Our ref: WA/2021/129266/03-L01
Your ref: 21/02286/F
Date: 06 April 2022

Construction of a coffee unit with drive-thru facility and indoor seating with associated access, car parking, landscaping and servicing parking

Land north west of Launton Road roundabout adjoining Skimmingdish Lane,

Title FLOOD VOLUMES SECTIONS 2 OF 3

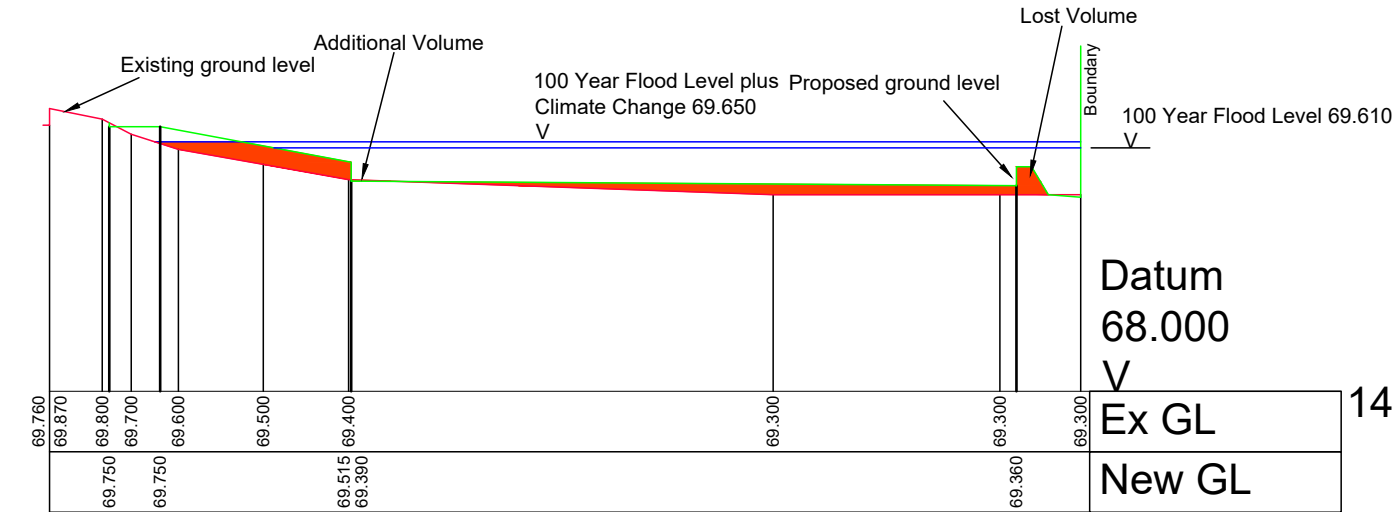
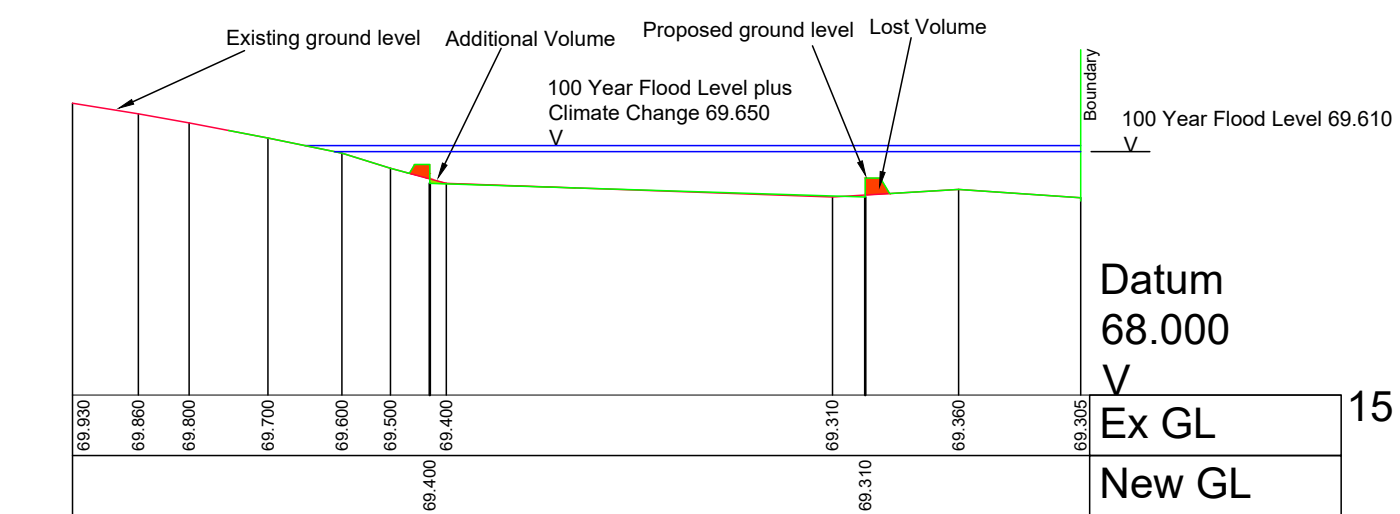
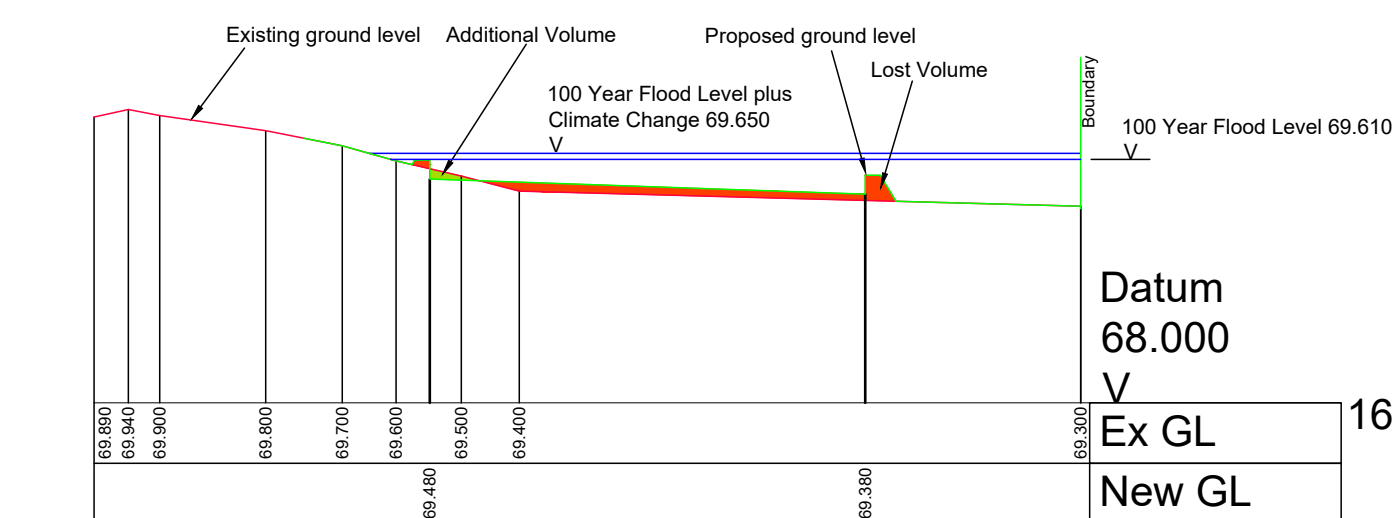
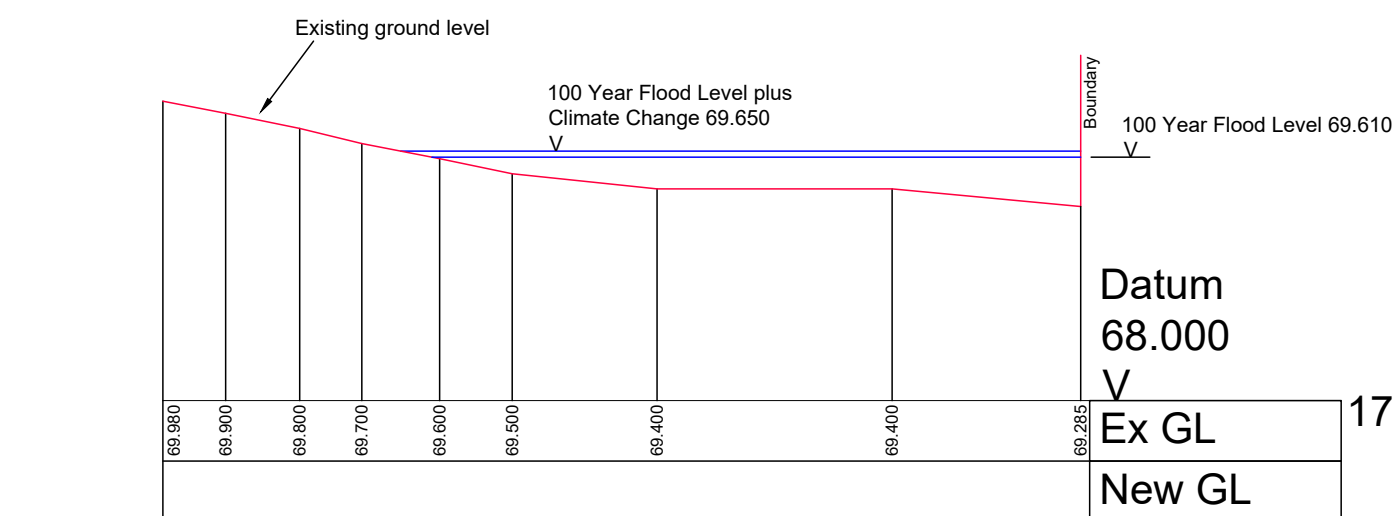
In addition, the submitted letter sets out that the floodplain storage compensation required for levels above 69.55m AOD has been reduced to 17.58m³ following a revision in the climate change allowance. However, it is not clear how this was calculated. Whilst there is some information in the three 'Flood Volumes Sections' drawings, it would be helpful for this to be summarised within the FRA. The tables provided in the submitted letter seem to only show the change in flood volume once compensation (through ground level changes) has been provided. For clarity, a table should be included that clearly shows for each 0.1m slice the total: volume of flood storage lost, the volume of flood storage gained, and the volume difference (this appears to have been provided in the first table within the submitted letter).

Further, if the highest climate change flood level is agreed to be 69.66m AOD as stated in the submitted letter from RSK (dated 24 December 2021), then the tables within the letter should be updated to include this flood level (currently the tables only go up to 69.65mAOD).
